RE: Bulli Seam Operations Project (MP 08_0150)
Appin Mine– Longwalls 709 to 711 and 905 Extraction Plan – request for additional information

I refer to your letter dated 7 March 2022, regarding the assessment of the Extraction Plan (EP) for Appin Mine's LWs 709-711 and LW 905 and the advice received from the Biodiversity Conservation Division (BCD) within the Department.

**Appin Area
7 and 9**
Longwall 905 and
Longwalls 709-711
Monitoring Locations
Overview
Figure 2

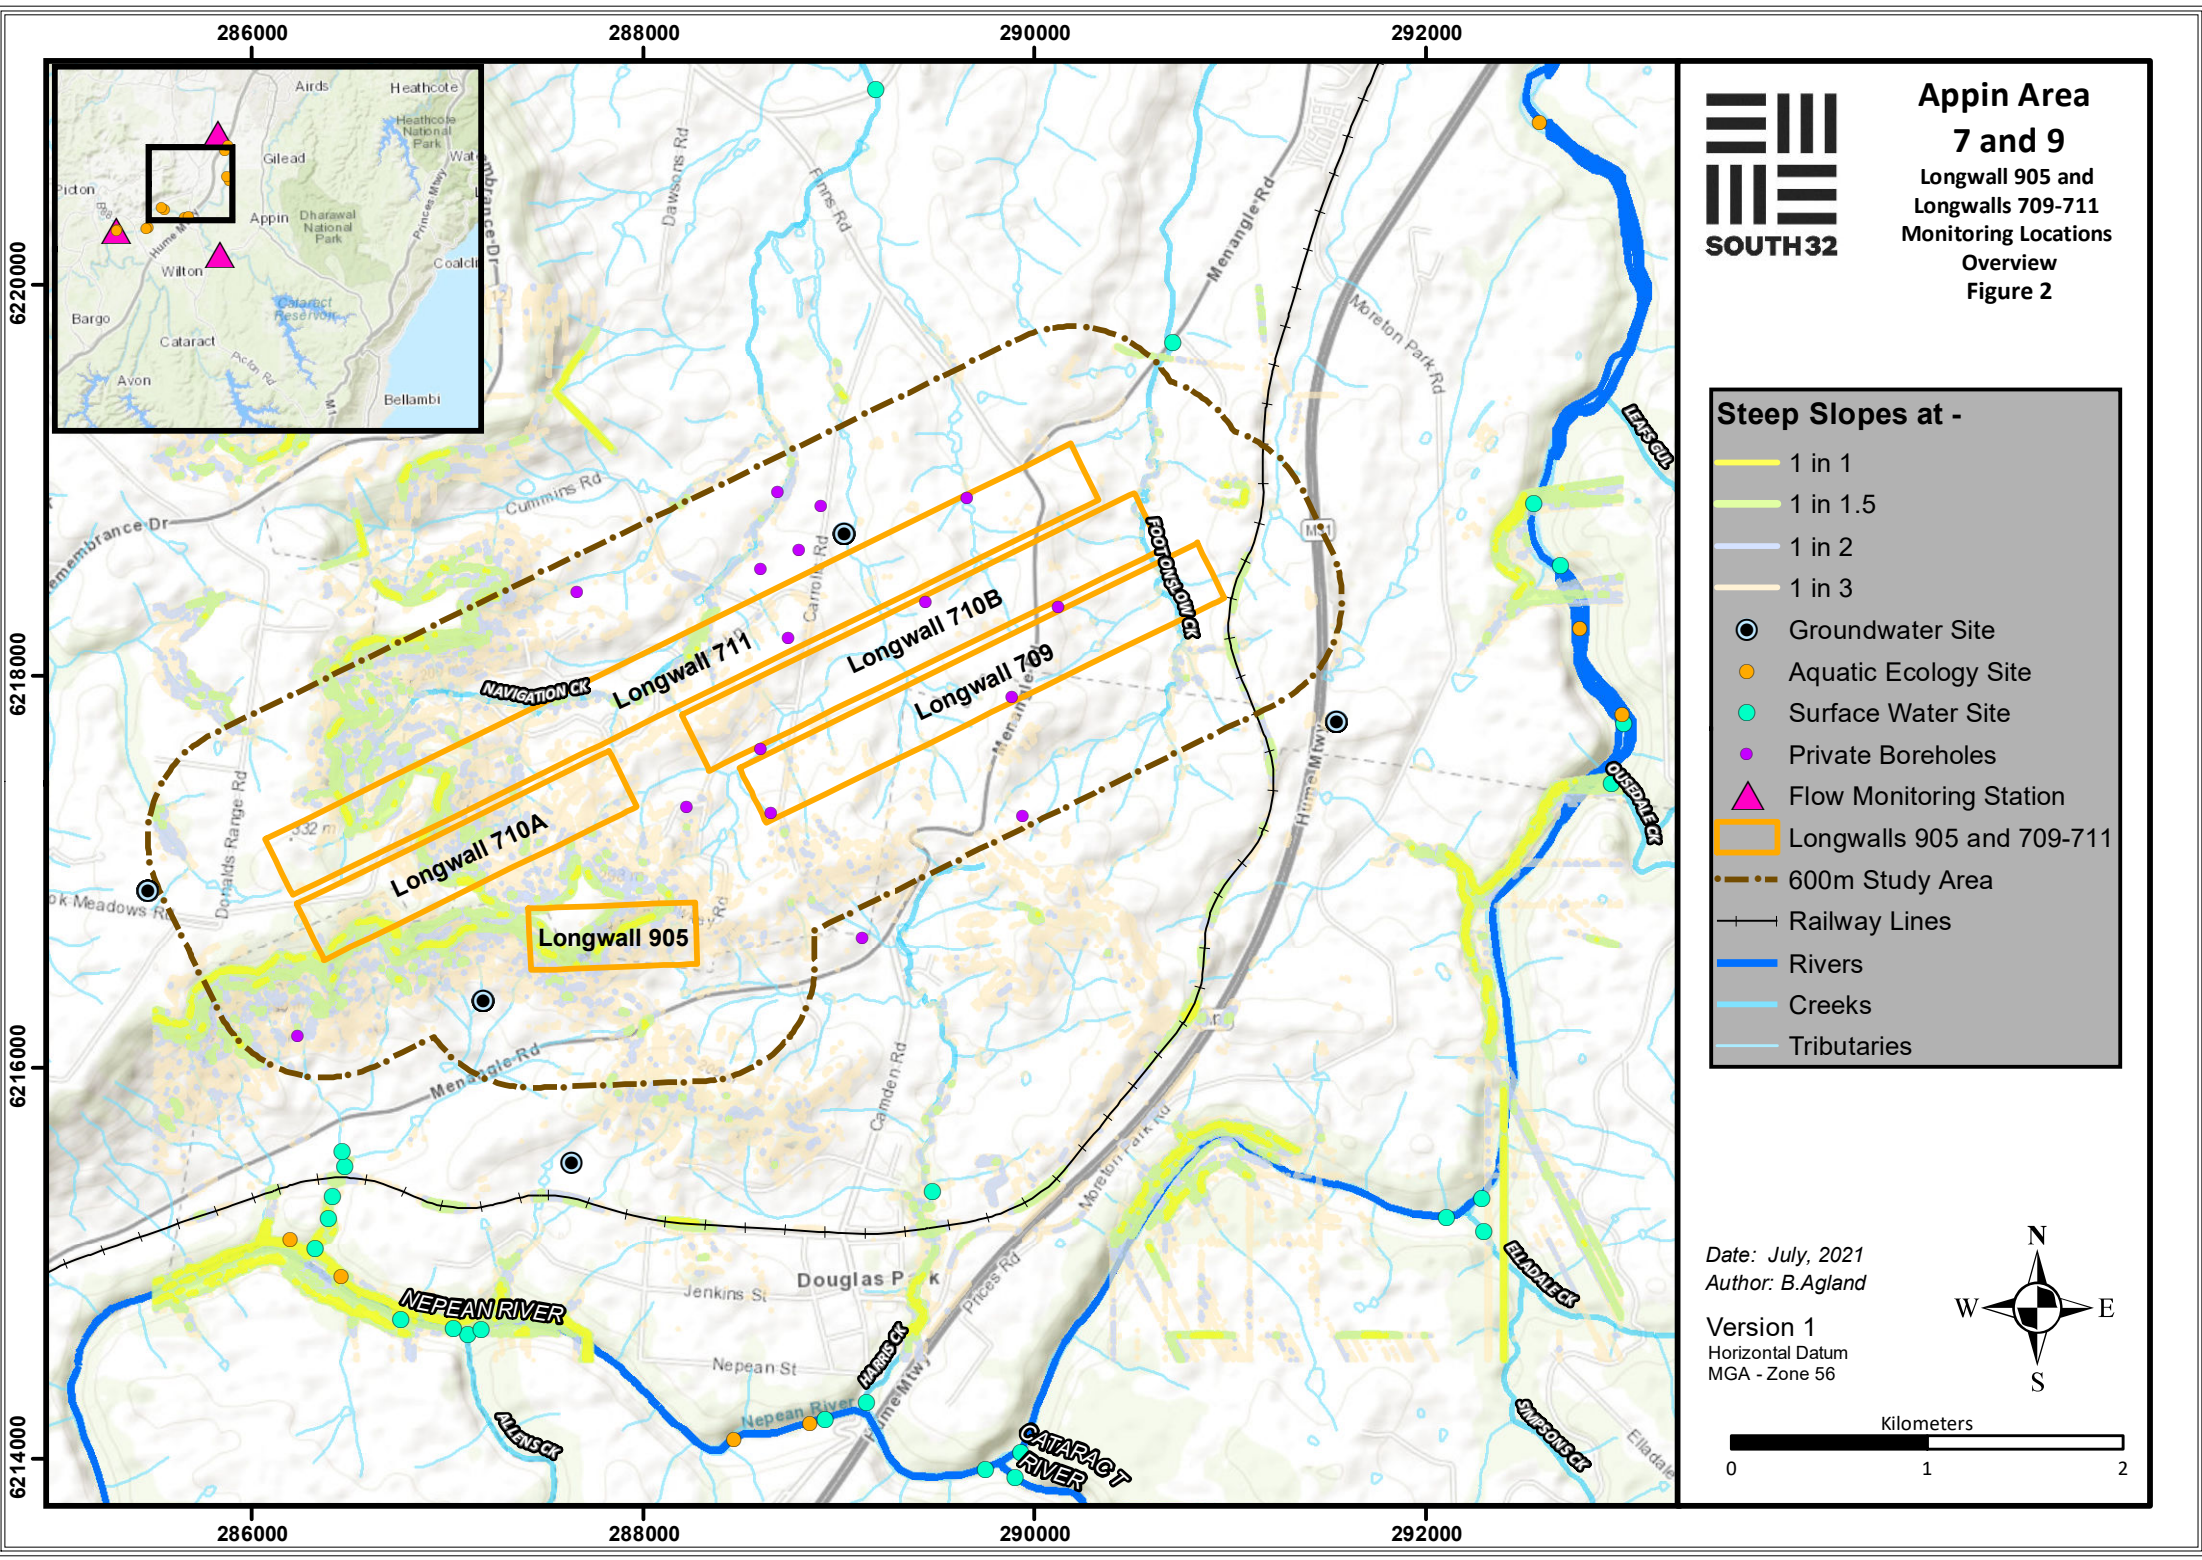
3	<p>Groundwater Assessment</p> <p>BCD considers that the Groundwater Assessment appears to rely on bore data from areas adjacent to the longwalls rather than in areas where maximum subsidence and impacts are likely to occur. The Department requires justification for the selection and exclusion of bores used to calibrate the groundwater model.</p>	<p>Monitoring boreholes above longwalls are required to be decommissioned with piezometers removed and capping prior to the extraction of longwalls for safety reasons. Unlike Dendrobium, these boreholes have not been routinely re-drilled and instrumented for post-extraction monitoring, hence their exclusion from the groundwater model.</p> <p>IMC will discuss the need for installing pre and post extraction monitoring with the specialist groundwater modeller and independent expert reviewer and implement on an as needs basis.</p>
4	<p>Groundwater Monitoring</p> <p>The Department notes that there is only one alluvial monitoring bore near the third order section of Navigation Creek proposed in the monitoring program. The</p>	<p>Pending landholder access agreement, IMC will install additional alluvial monitoring boreholes in third order sections of Foot Onslow Creek and Navigation Creek Tributary 1; one for each watercourse.</p>

<p>Department requests that IMC consider expanding the existing monitoring program to include alluvial monitoring bores in third order sections of Navigation Creek, Navigation Creek Tributary 1 and Foot Onslow Creek that will be directly undermined and ensure that at least 12 months of data have been collected prior to extraction, wherever possible. Consideration should also be given to inclusion of piezometers over the longwalls.</p>	<p>Where access is granted, IMC will install pre and post extraction groundwater monitoring for the listed streams over the longwalls within the Hawkesbury Sandstone.</p>
5	<p>Surface Water Monitoring</p> <p>The surface water monitoring sites shown in Figure 8 of SLR (2021) and Figure 4 of SLR (2022) do not include any flow monitoring in watercourses or water level monitoring in pools over the proposed longwalls or at the existing NAV1, FO1 and HC10 water quality monitoring sites.</p> <p>The Department requests IMC update the existing monitoring program, or provide justification otherwise, for additional monitoring of flows and standing water levels in watercourses above and adjacent to the proposed longwalls.</p>	<p>Geomorphically, Navigation Creek, Foot Onslow Creek and Harris Creek are suitably characterised as an ephemeral chain-of-ponds system, particularly in the catchment where the proposed longwalls are located.</p> <p>Where these creek systems are located on private property, they are dominated by farm dams.</p> <p>Any surface water monitoring of these creeks, above the proposed longwalls, would essentially be reduced to monitoring the water levels of farm dams. IMC does not consider this to be a suitable monitoring strategy, given that landholders tend to use these dams (i.e. extract water).</p> <p>Monitoring sites above the proposed longwalls within sections of Navigation Creek and Foot Onslow Creek, on public property, were investigated during the development of the Extraction Plan application. Sites NAV2 and NAV3 (Figure 1), were investigated; no suitable sites for pool water level or flow monitoring were found.</p> <p>The existing site HC10 has suitable conditions for the installation of a water level benchmark and this will be installed.</p>
